Attachment A – Mosman High School Upgrade SSD-10465 – Response to Request for Additional Information	
Issue	Proponent Response
Public Authority Submissions	
Department of Planning, Industry and Environment	
<ul style="list-style-type: none"> A map indicating the precise location of the existing accessible parking space on Belmont Avenue and the information demonstrating the feasibility of this being utilised by the school given likely existing community demand having regard to the existing surrounding developments (commercial areas, residences, bowling club) and Council's objection to its use as part of the operation of the school. 	<p>Following a review of the accessible parking space on Belmont Road, it has been determined by PTC consultants that the accessible car space was removed during the process of the SSD application.</p> <p>The exact location of this space and the pedestrian connectivity between the space and the school entry are shown in Figure 2 and Figure 3 at Attachment C. There is a raised zebra crossing across Belmont Road providing a level path to the school.</p> <p>It is unclear to the project what the exact purpose of the accessible space was and why it was remov

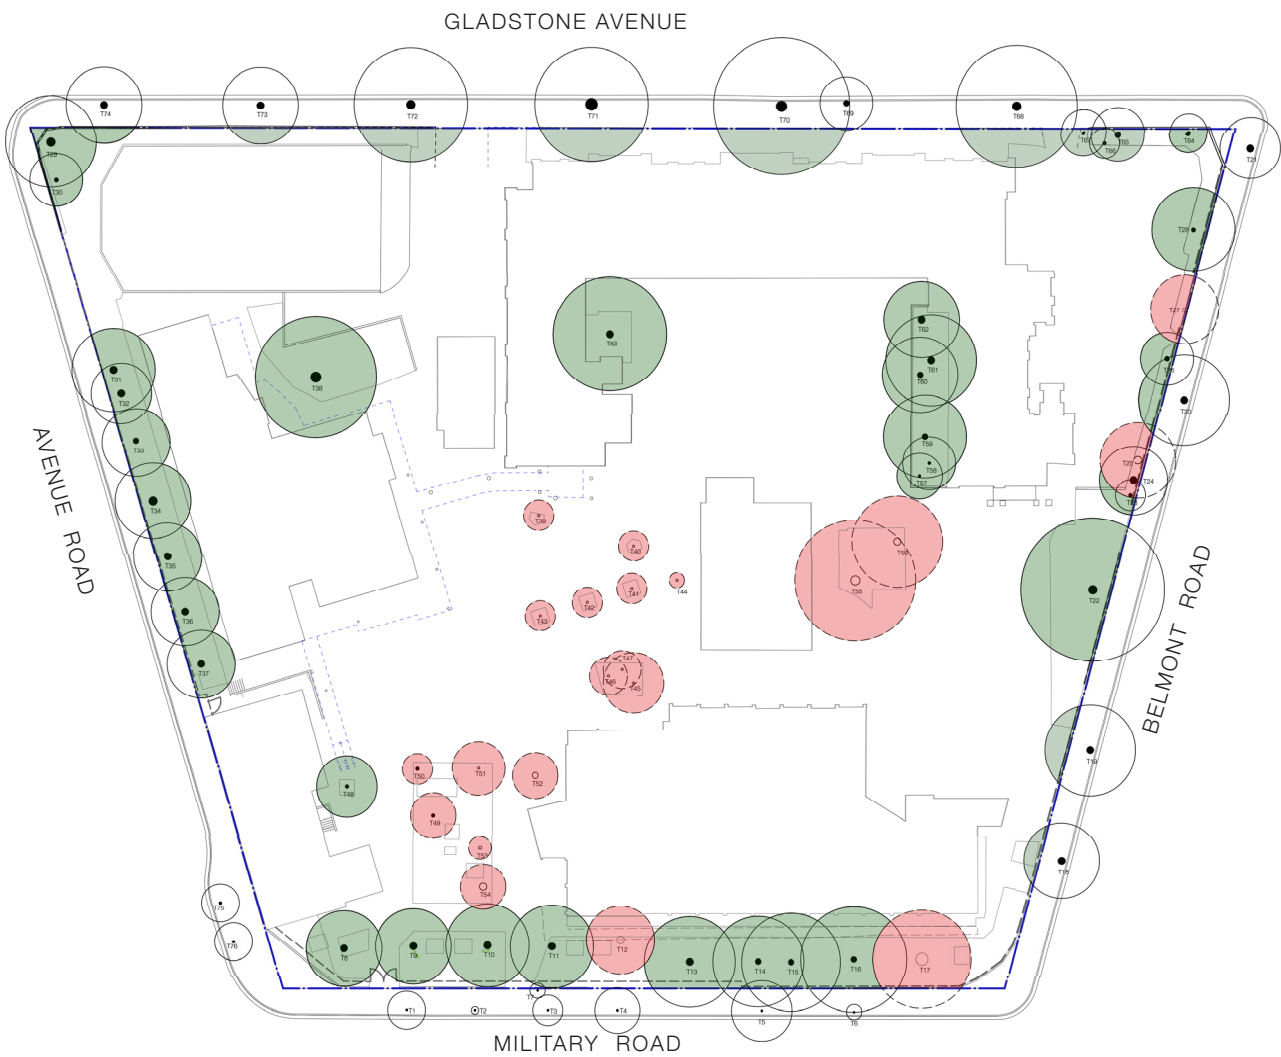
<ul style="list-style-type: none"> justification for not meeting the 28% canopy cover recommended by the Government Architect NSW, noting that this represents a reduction below that in the <i>Draft Greener Places Design Guide</i>. 	<p>The current proposal for Mosman High School includes the planting of 34 new trees and a significant increase of the canopy cover of 3.4% to a total of 24.6% canopy cover and equates to an additional 492 square metres of canopy cover.</p>

<p>It is noted that tree canopy provision is accepted and commended by the NSW Government Architect Office (GAO).</p> <p>Due to the current conditions and constraints of the site there are limited opportunities to increase the canopy cover. Considering this, the increase in GFA on the site has required the landscape design proposal to balance the requirements for open play space and the need for canopy cover. The current proposal manages to do both through careful configuration of the landscape spaces on the ground plane and utilisation of terraces on level 3 & 4. The design includes tree planting around the perimeter of the two proposed open play areas (basketball court & lawn) on ground level, replacement tree planting along Military Road and replacement tree planting within the arts courtyard. In addition, tree planting has been maximised on the rooftops (Level 3 & 4) in accordance with structural engineers' guidance and recommendations.</p> <p>Therefore, there is no further opportunity to increase the tree canopy beyond 24.6% without compromising the provision of playground space and building development.</p> <p>For further information refer to the Landscape Statement prepared by Black Beetle at Attachment B, which also provides illustrations on the proposed tree canopy coverage submitted as part of the SSDA submission.</p>
